**Dargues Reef Gold Project
Environmental Assessment**

I refer to your letter dated 27 September 2010 seeking comments from Industry and Investment NSW (I&I NSW) on the Environmental Assessment (EA) for the proposed Dargues Reef Gold Project by Big Island Mining Pty Ltd, a wholly owned subsidiary of Cortona Resources Limited.

Technical officers of I&I NSW have reviewed the EA and provide the following comments:

Figure 2.9 presents the proposed final landform. In summary, the final landform would include the following components.

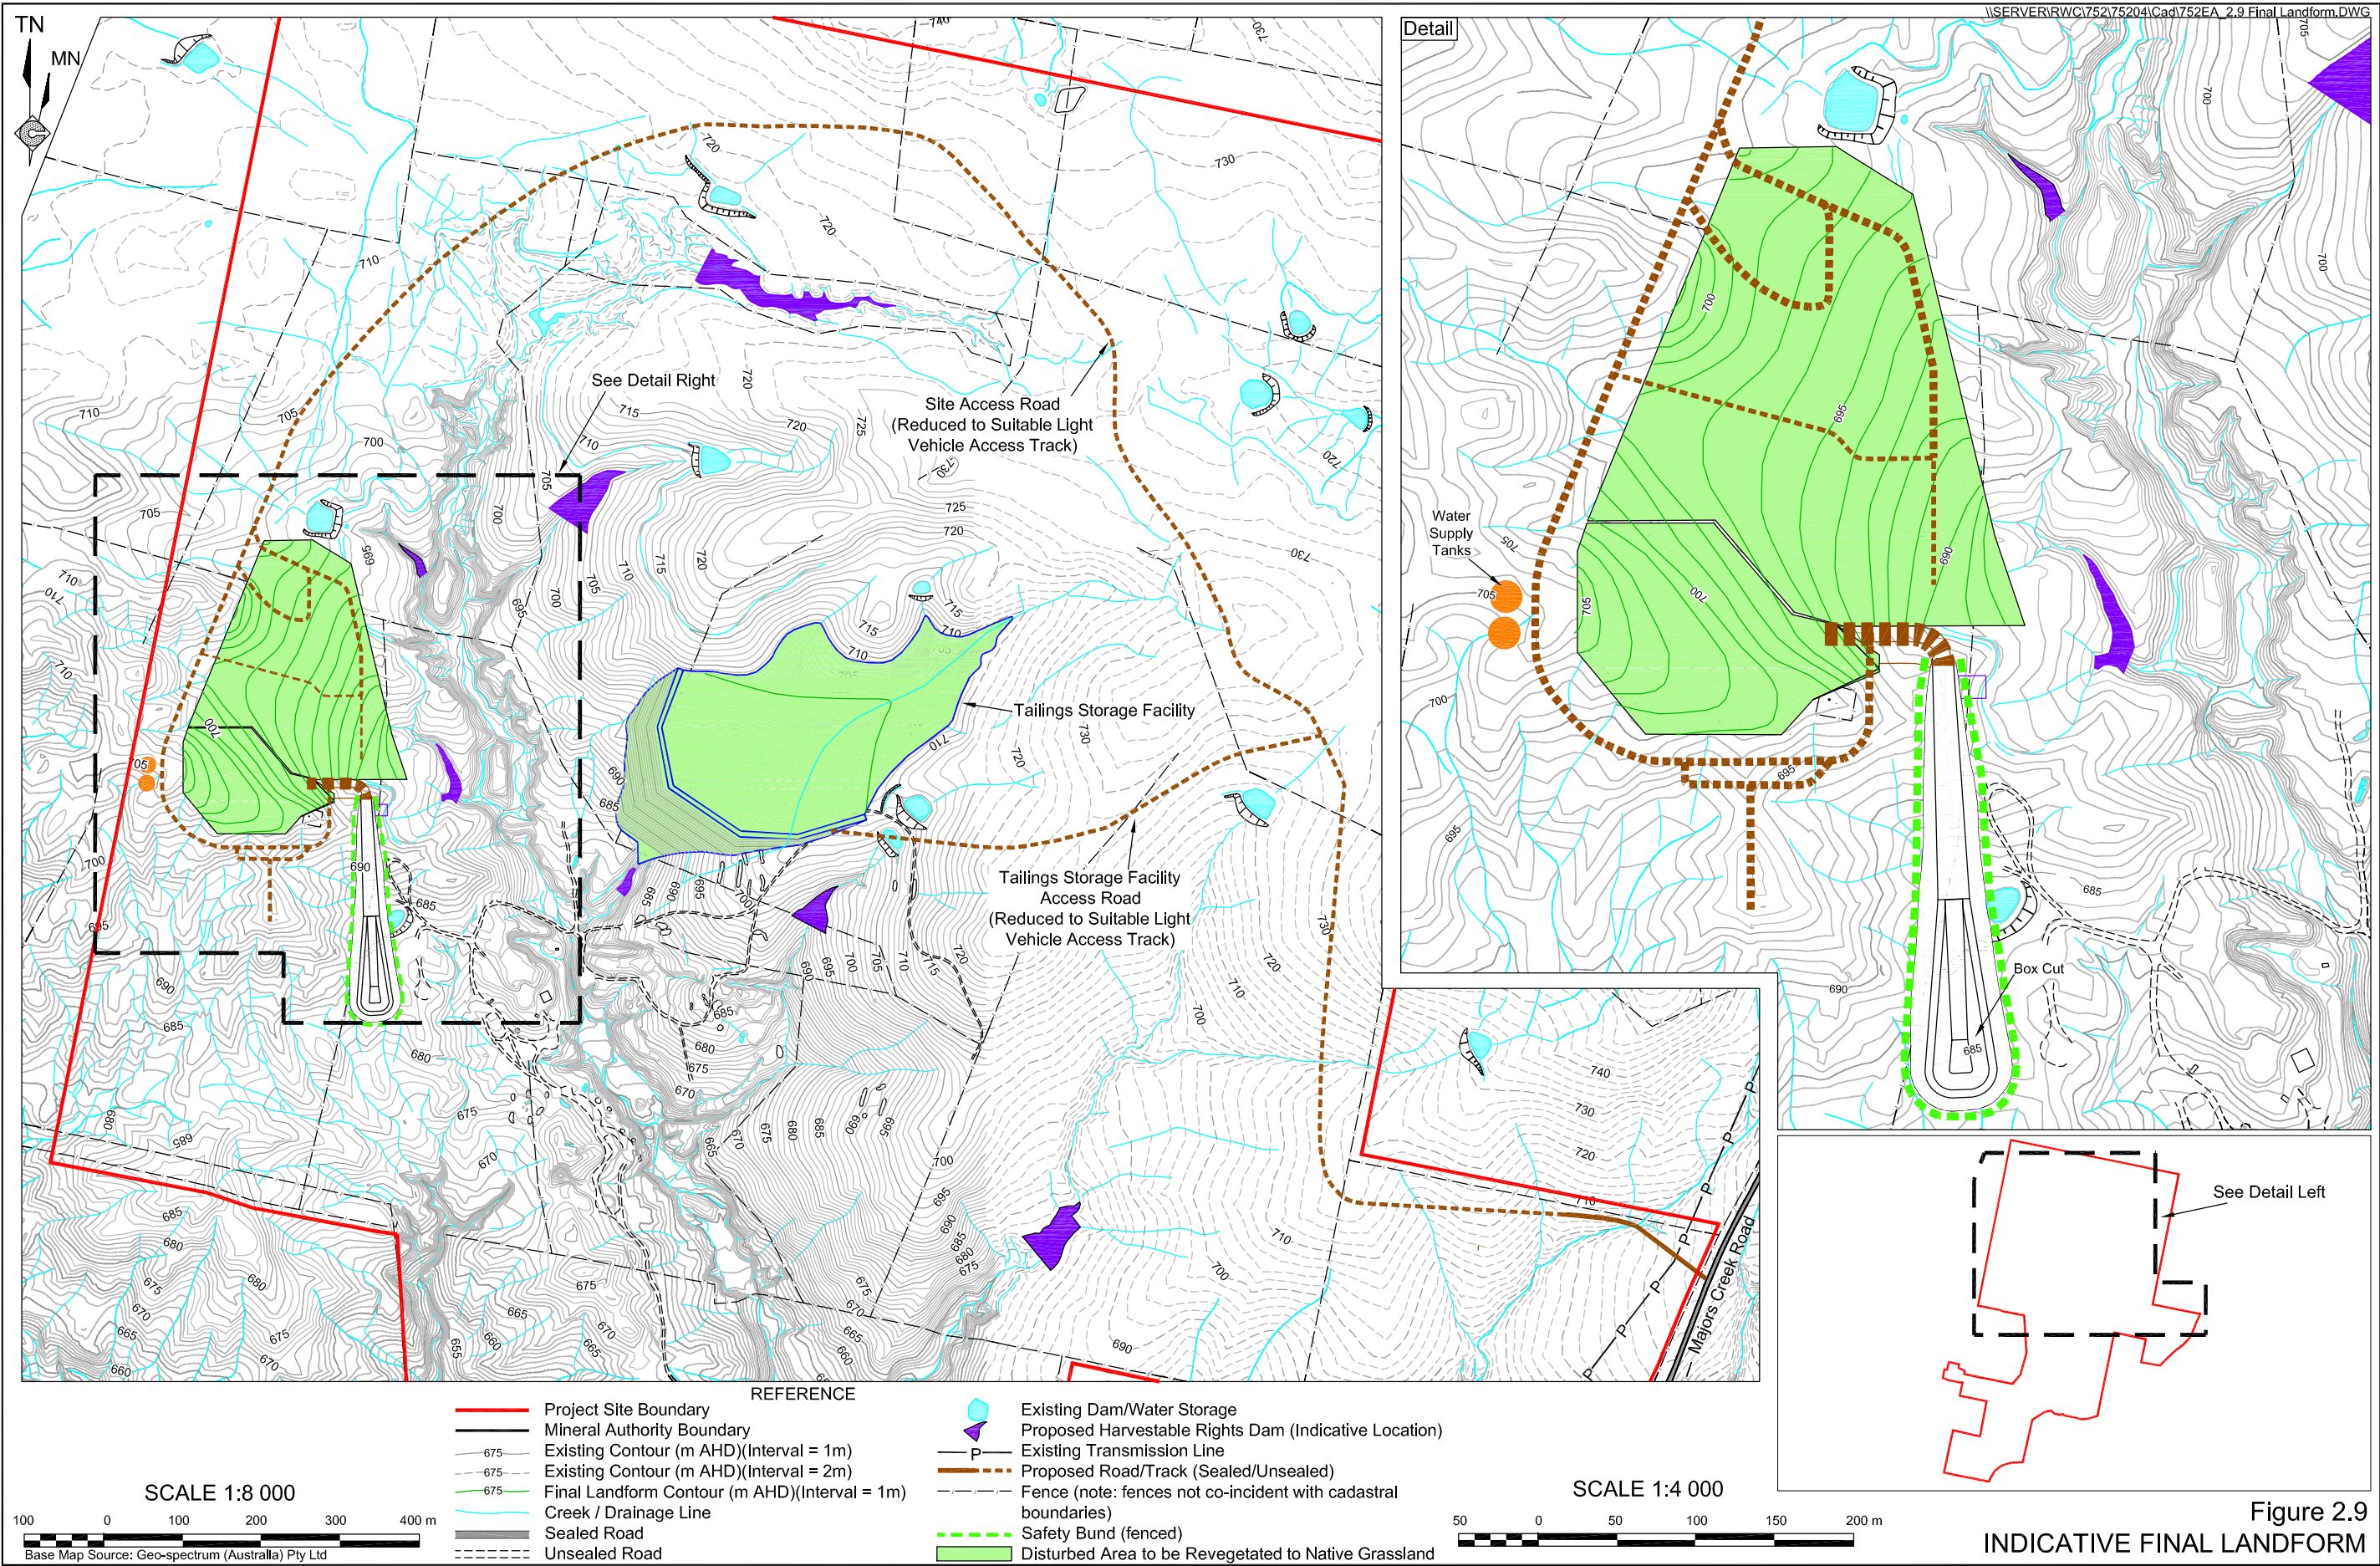
Retention of the box-cut in the final landform

The retention of the box-cut in the final landform is not supported by I&I NSW for the following reasons:

- The box-cut landform is not consistent with the proposed final land-use of agricultural grazing and the existing topography of gently sloping hills and valleys; and
- Ongoing maintenance will be required for the box-cut fence and safety bund, which will be passed onto subsequent landowners.

I&I NSW recommends that the retention of the box-cut is either removed from the final revised version of the EA or a condition is specified by the Department of Planning that the box-cut be rehabilitated to a landform consistent with the pre-mining topography. The eventual rehabilitation of the box-cut must be planned for in the initial stages of the mine development (i.e. stockpiling suitable quantities of fill material and topsoil). This process can be managed through the "Rehabilitation Plan".
